Application No: CM/16/21/PL
Site Address: Bairds Farm Shop, Garden Centre Crookthorn Lane Climbing BN17 5SN
Description of works: Convert existing on site storage to picnic area with fast food Cafe. This application may affect the setting of a Listed Building. This application is in CIL Zone 5 (Zero Rated) as other development.

Thank you for your internet representation made on 31st May 2021 which has been recorded as an objection with the comments as follows:

Block Plan
Scale: 1:500

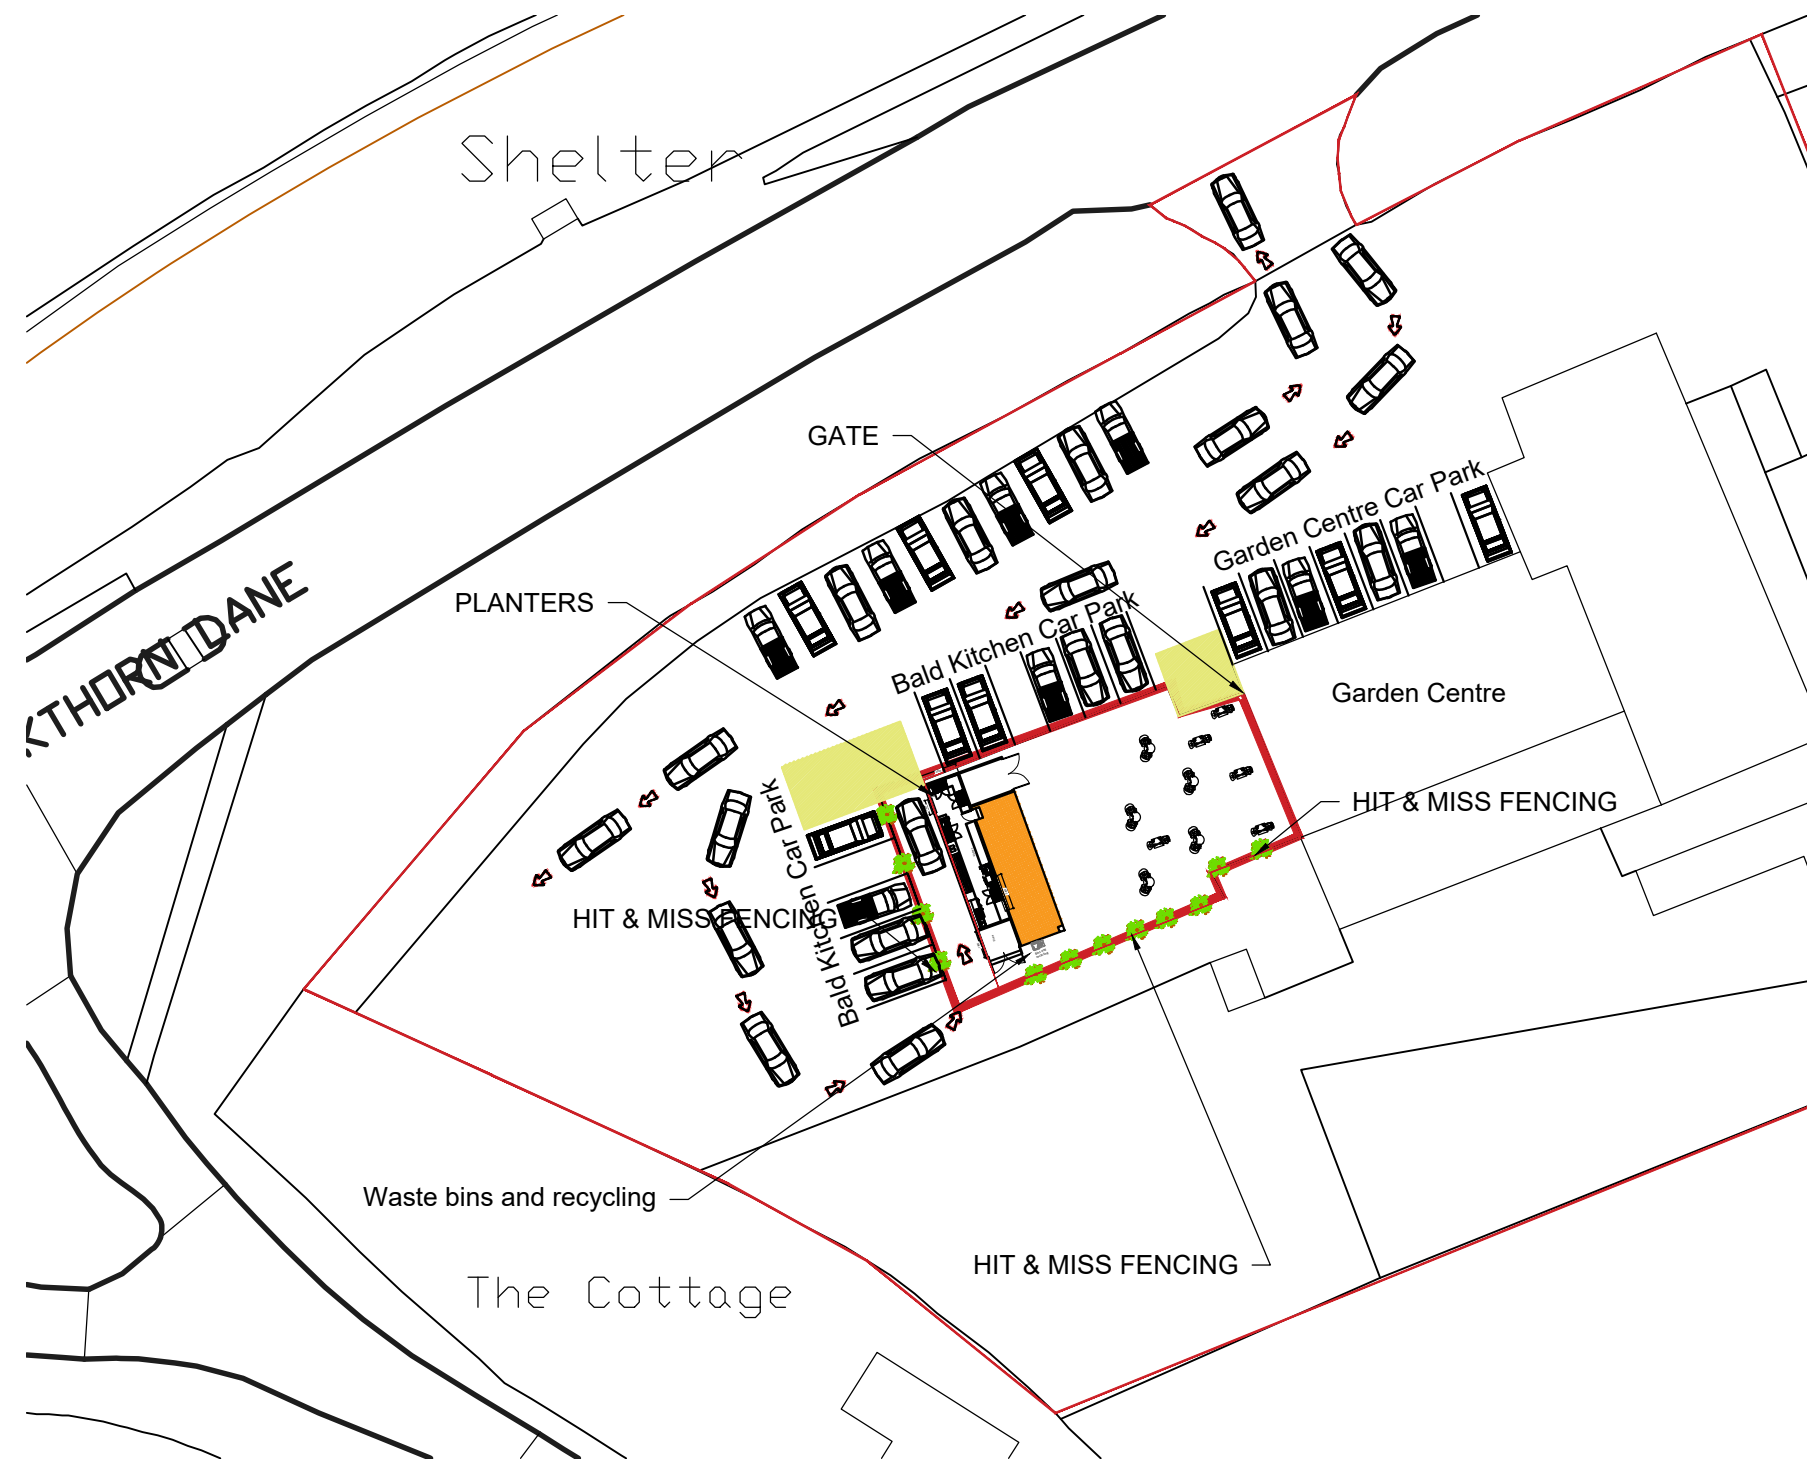
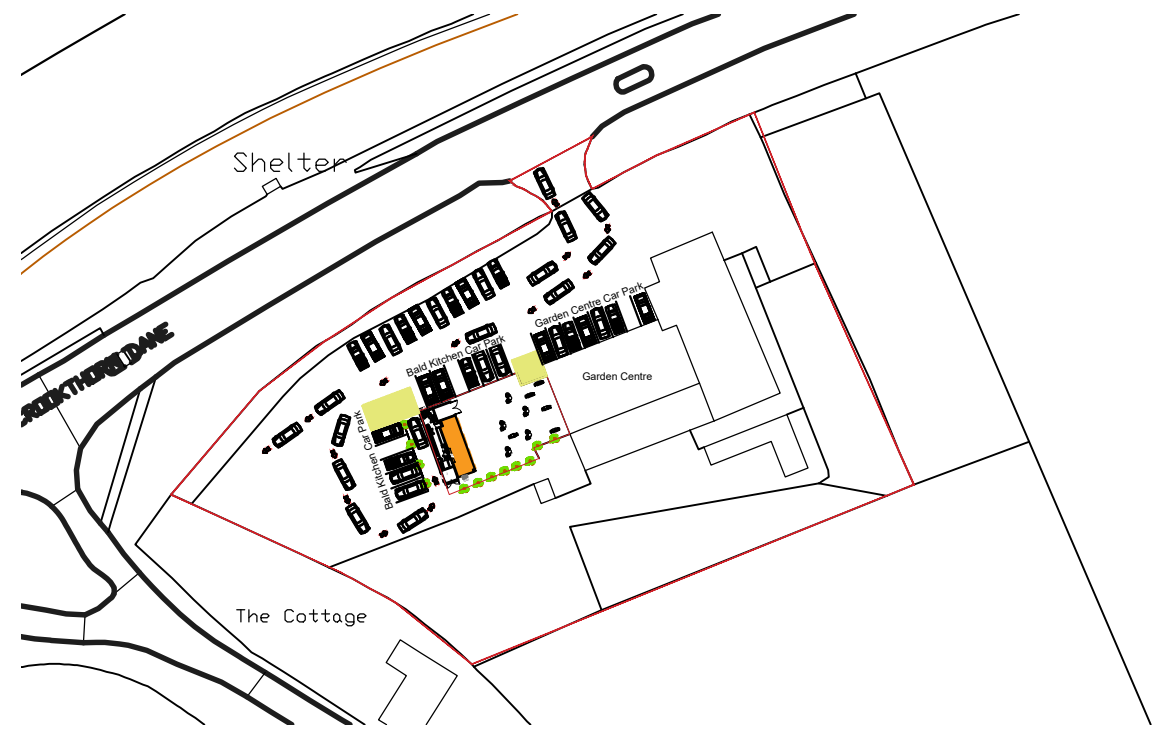
Access into the site and out onto the busy A259 will add to congestion at peak times. There is very little parking facilities on the site and I fear the drive through congestion will spill out onto the A259 causing further traffic delays, because the area is too small to facilitate a drive thru.

Dangerous design, with reference to the drawing (PL2), vehicles exiting the drive thru coffee collection point will have to cross the path of incoming vehicles. This is not logical approach to the standard design of clockwise drive thru outlets and will likely cause accidents as larger parked vehicles such as vans and trucks will restrict the view of smaller cars leaving the drive thru.
